Application No: AW/325/21/HH
Site Address: Blue Haze 37 The Drive Aldwick PO21 4DT
Description of works: Erection of single storey side/rear extension, front porch extension and detached garage to front
(This application may affect the character and appearance of the Craigwell House, Aldwick Conservation Area)

Thank you for your internet representation made on 5th November 2021 which has been recorded as an objection with the comments as follows:

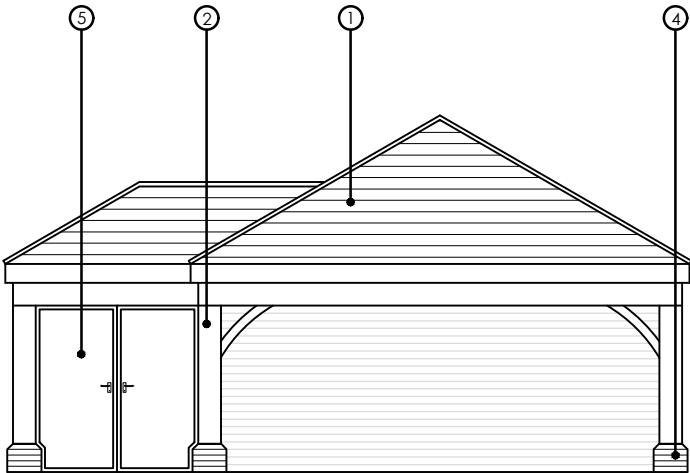
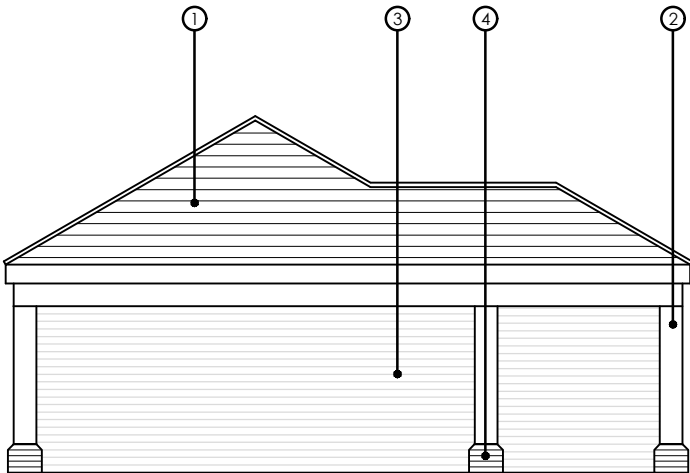
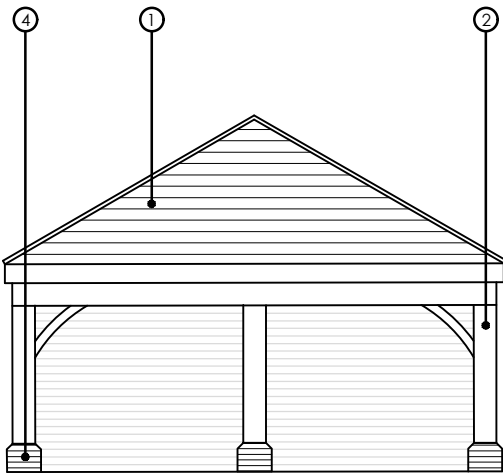
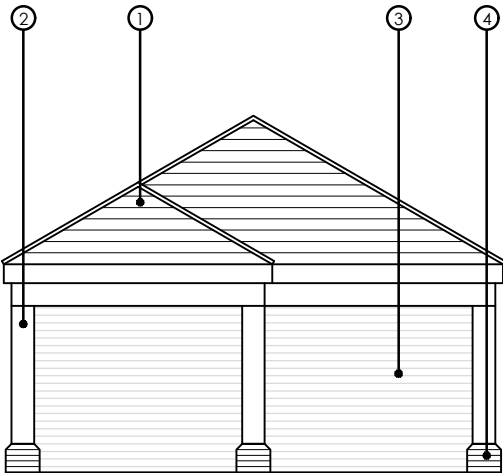
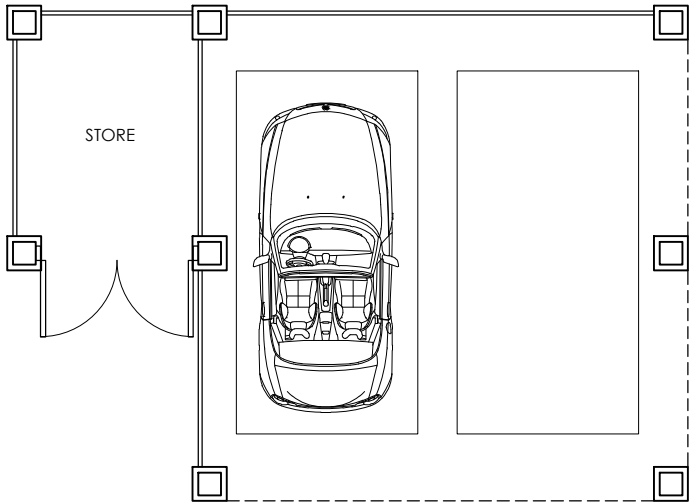
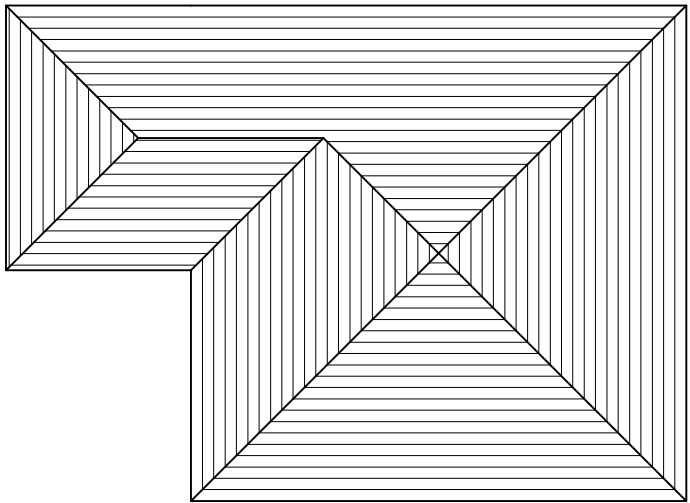
I totally agree with the Parish Council that this development is excessive and incompatible with the existing building and its setting. In particular, the new garage building to the front of the property and The Drive, breaks the open, spacious appearance within the Craigwell House Conservation Area and despoils its prestigious appearance and character entirely. The frontage of the property presently reflects the character and appearance of the CA and must be protected from over development such as this proposal.
